| Application number: 2025/93543 | |
| What is the application for?: | Erection of 33 dwellings (c3) with access from Clough Road and associated works |
| Address of the site or building: | land at, former Clough Mill, Clough Road, Slaithwaite, Huddersfield, HD7 5DB |

Visibility Splay Drawings

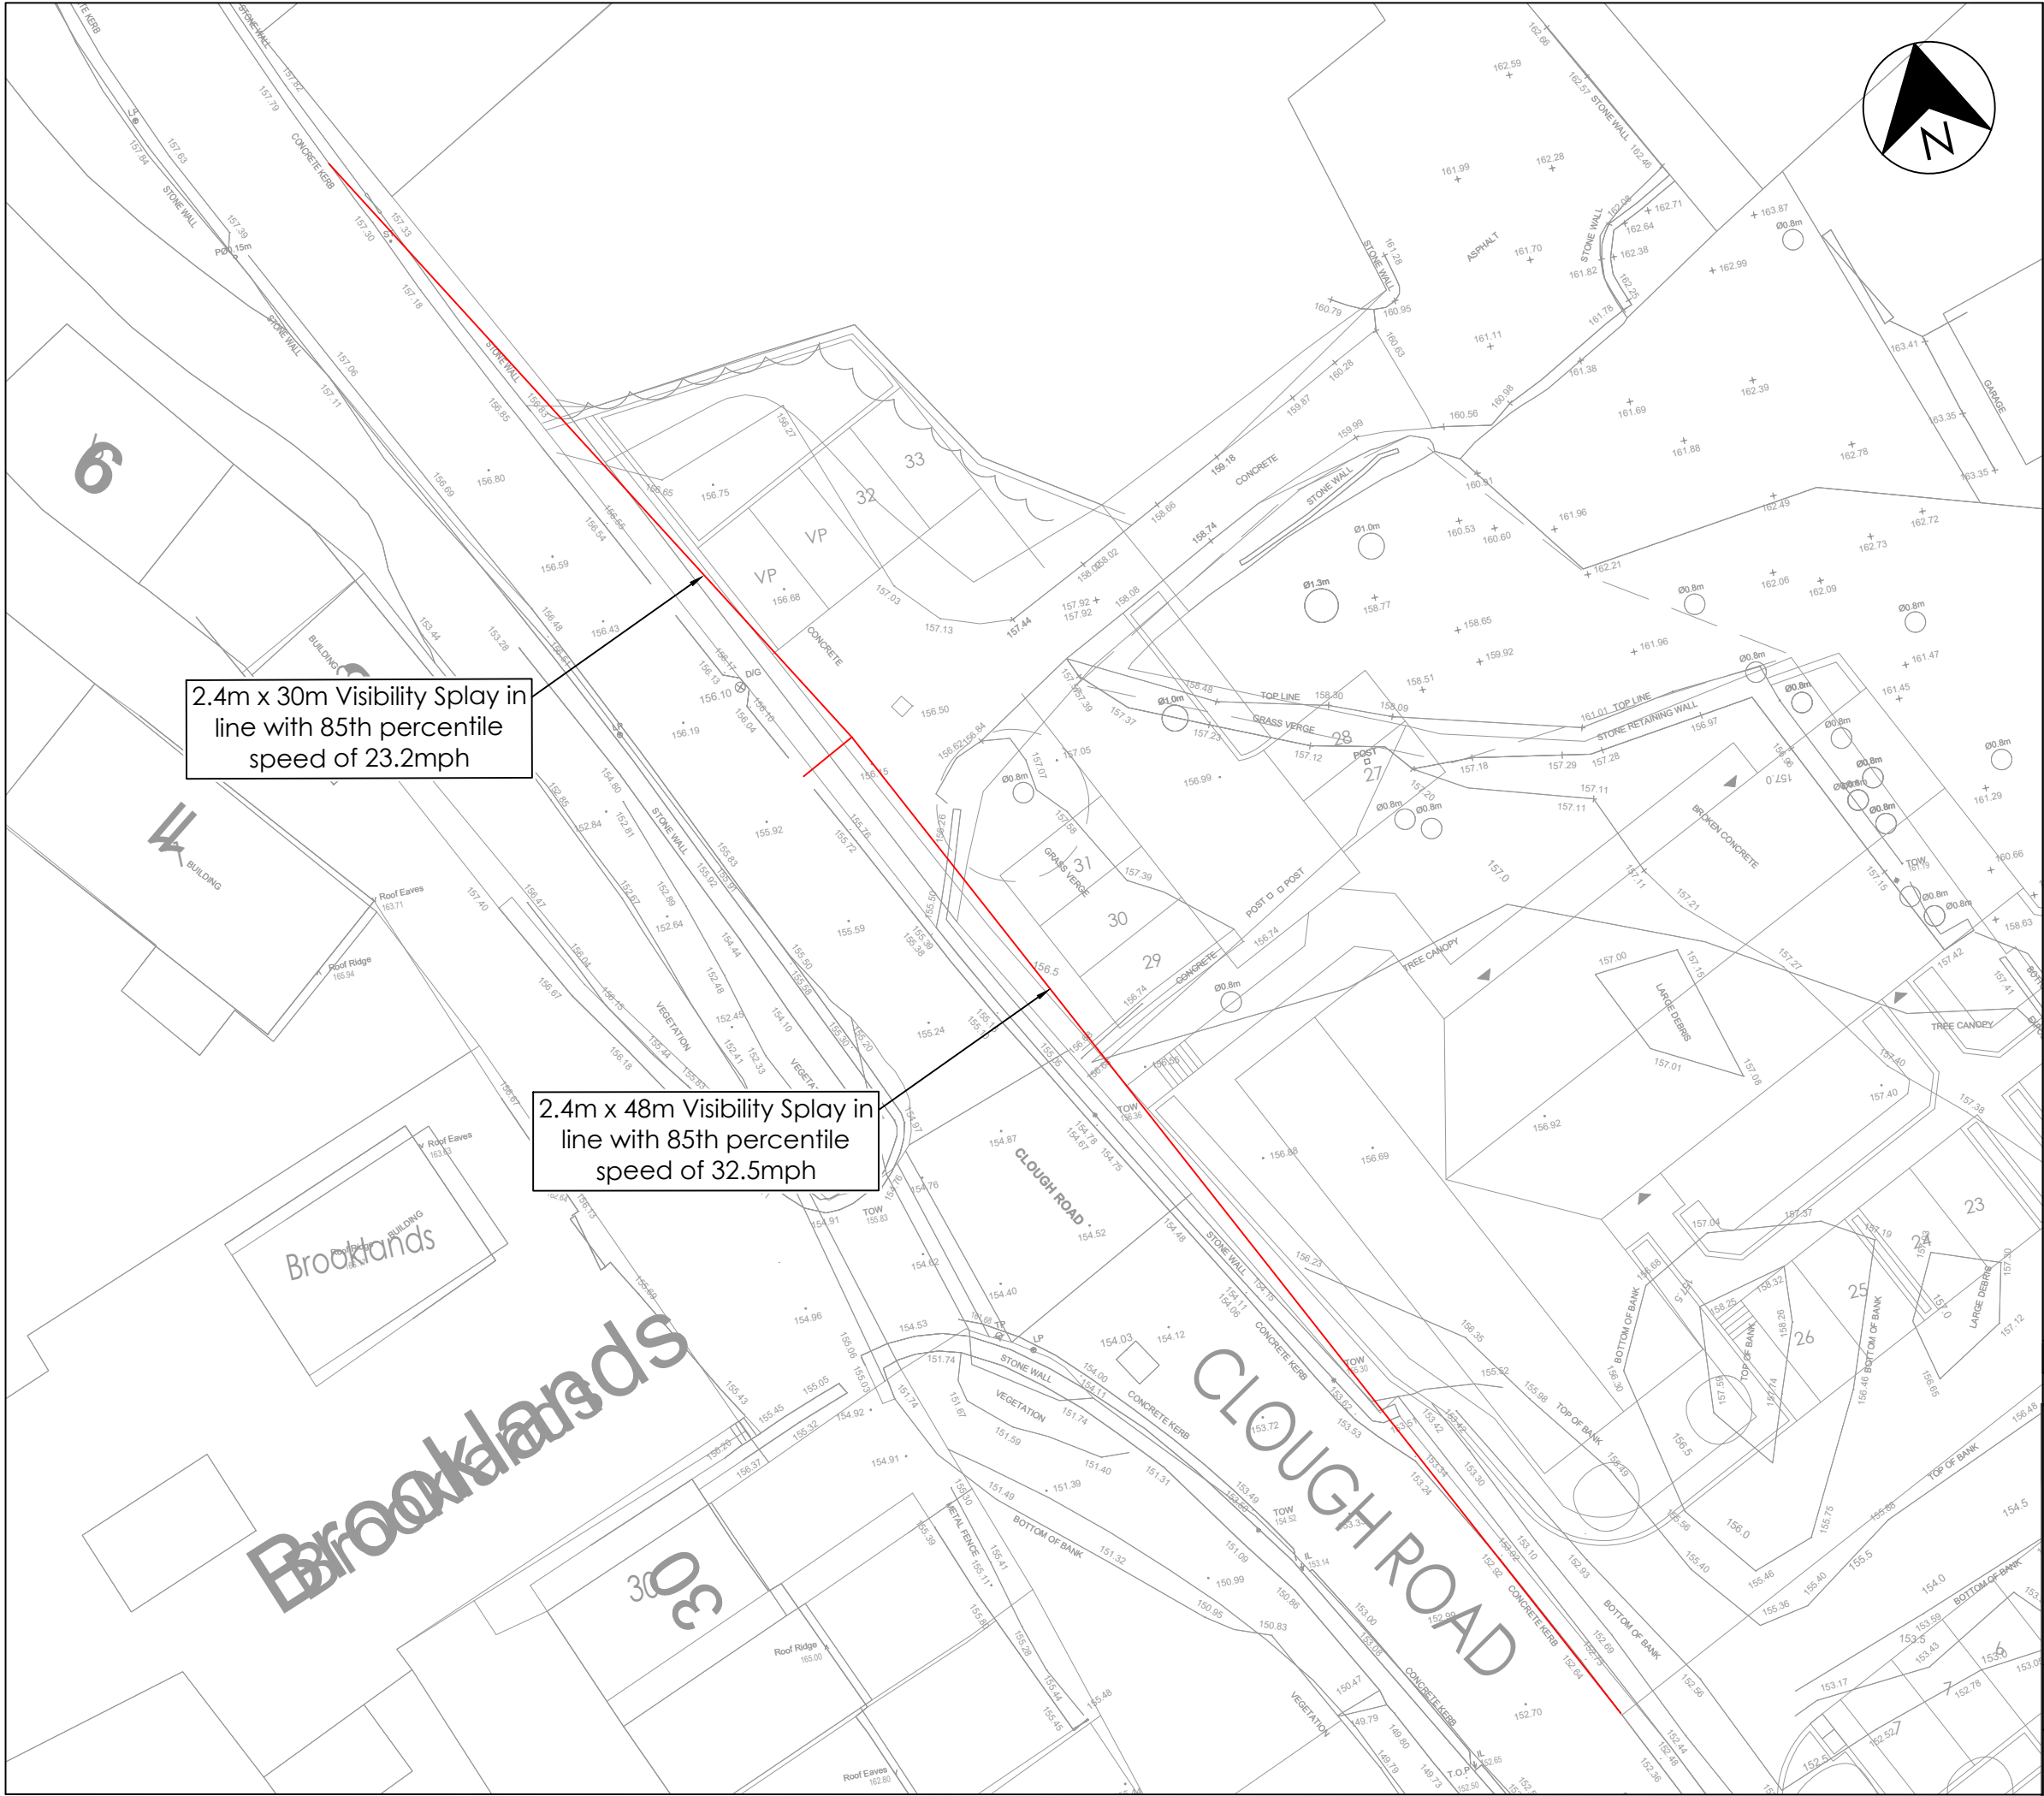
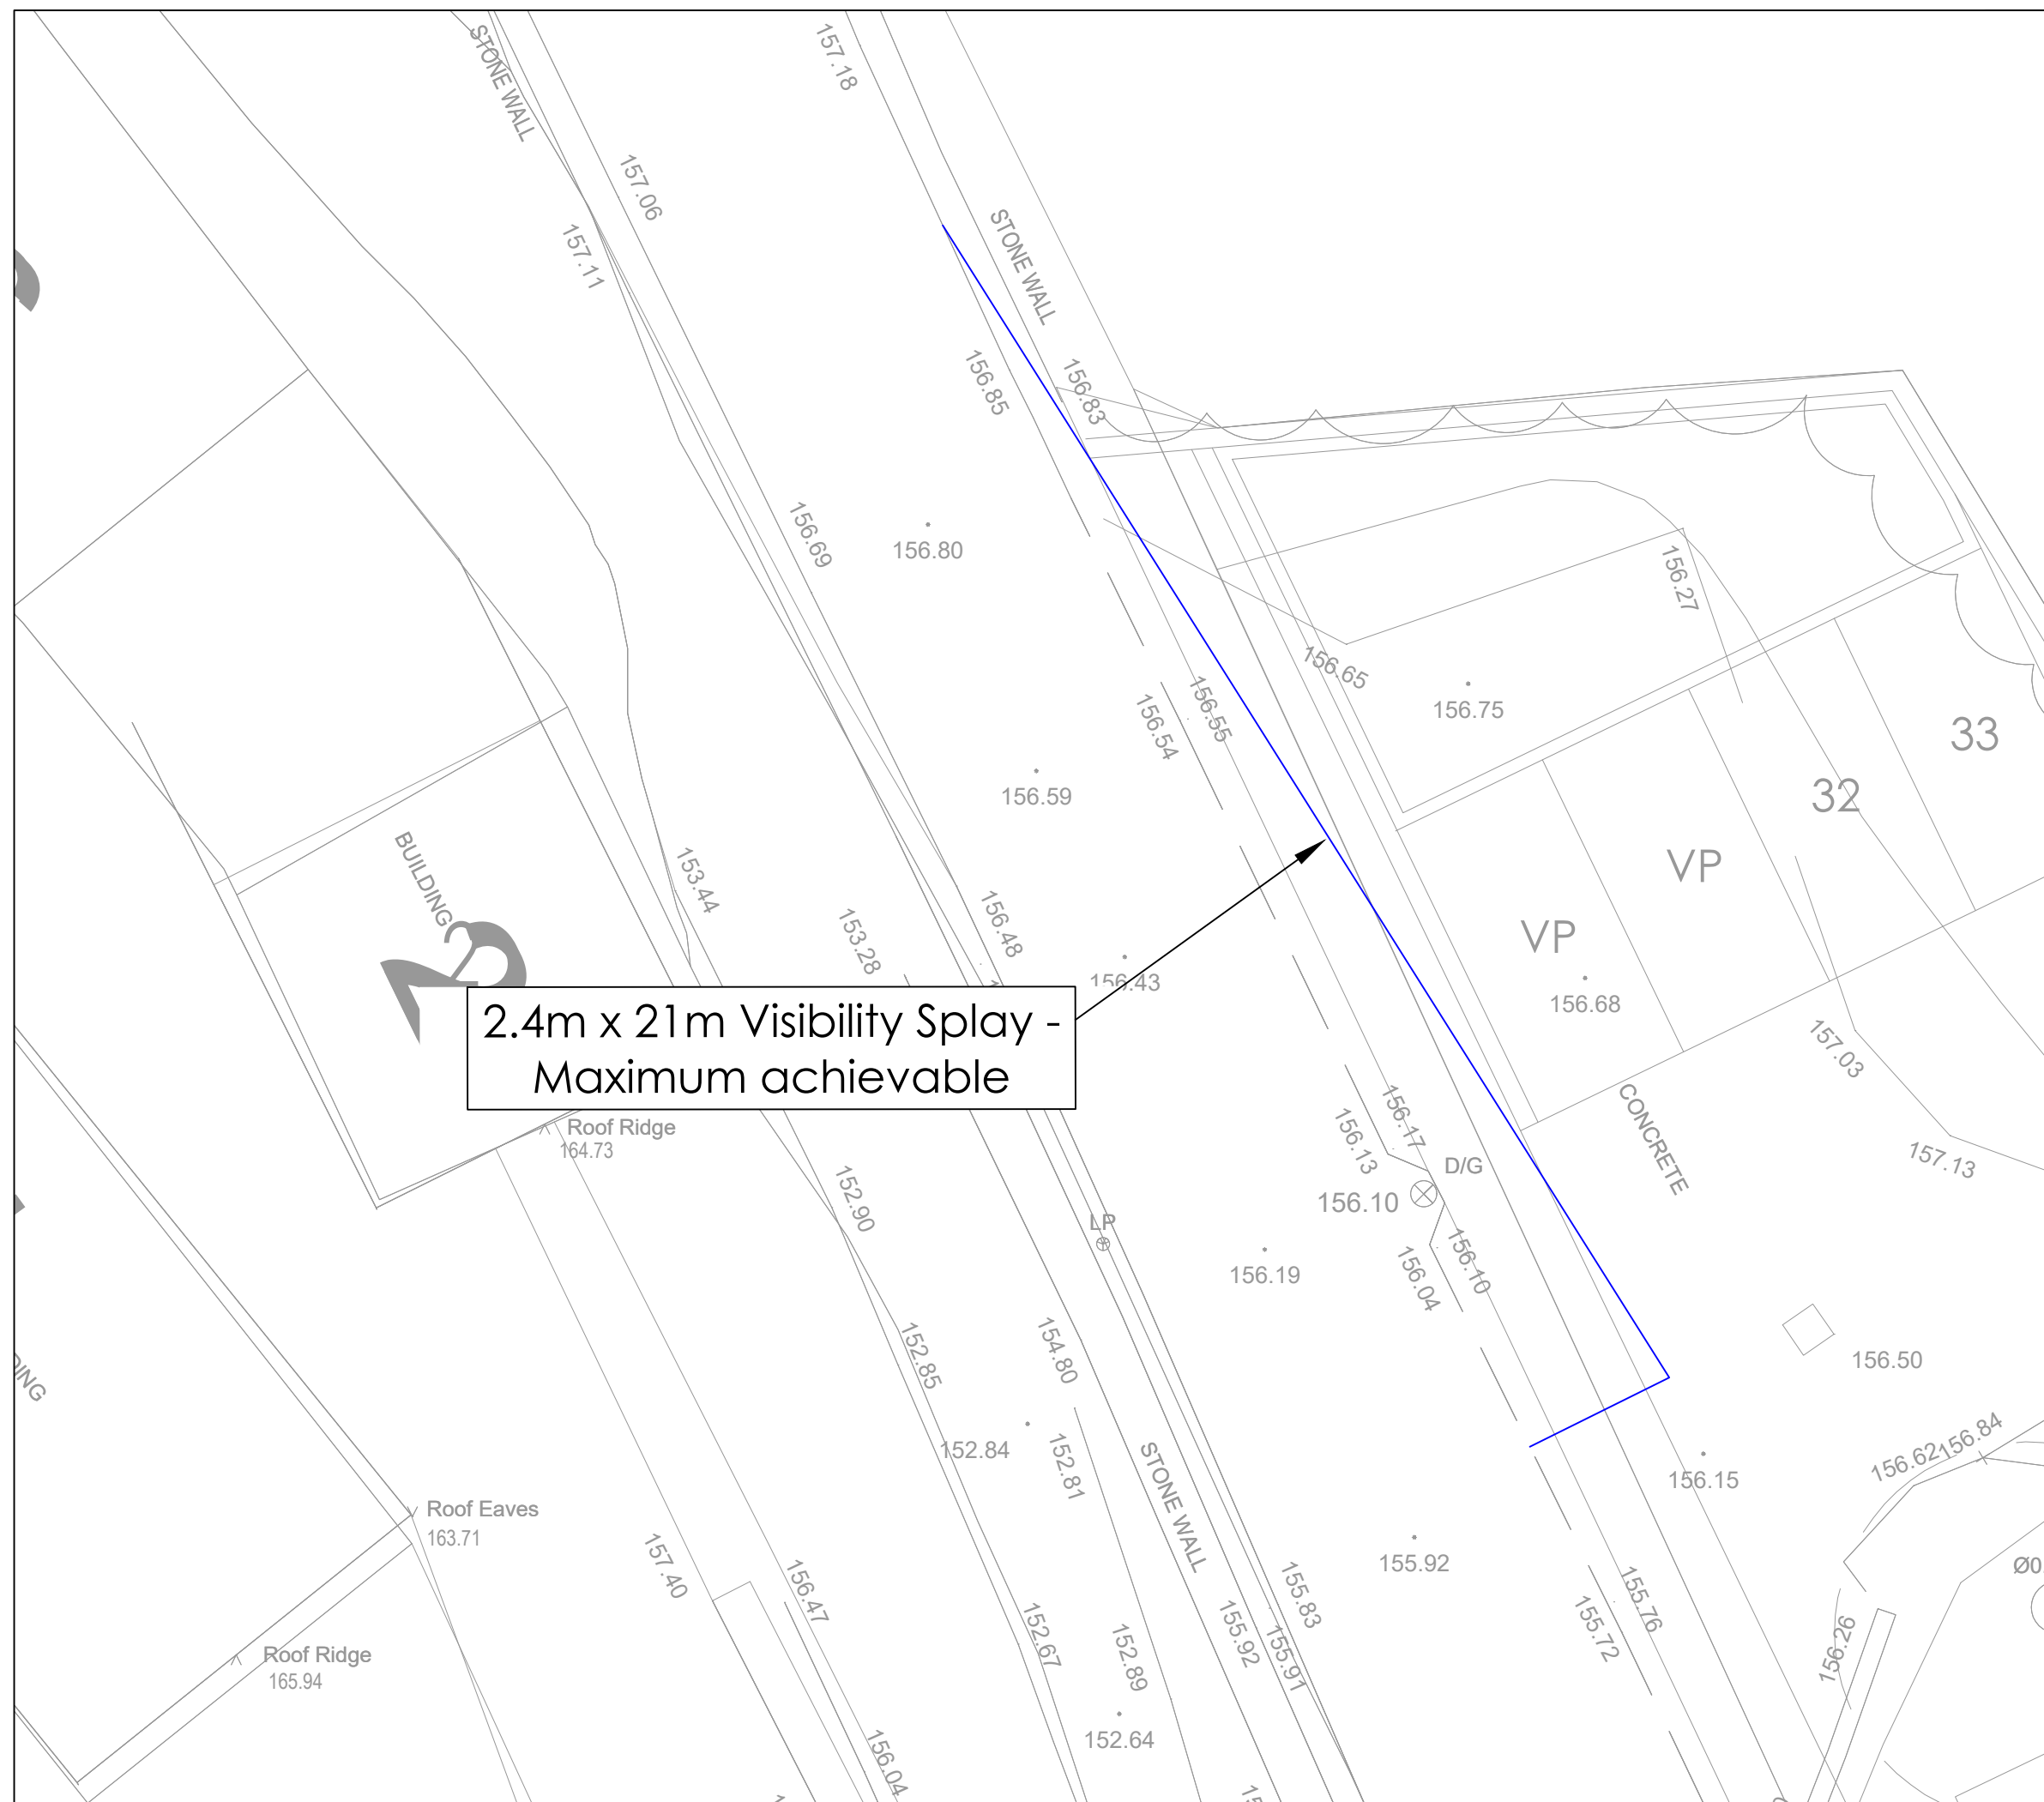
the most narrow point of the road where two way traffic is not always possible. The Transport Assessment does not include any modelling to indicate if the junction is even feasible at that location, or how right hand turns will be safely managed for vehicles turning into or out of the development. No visibility splay assessment has been included.
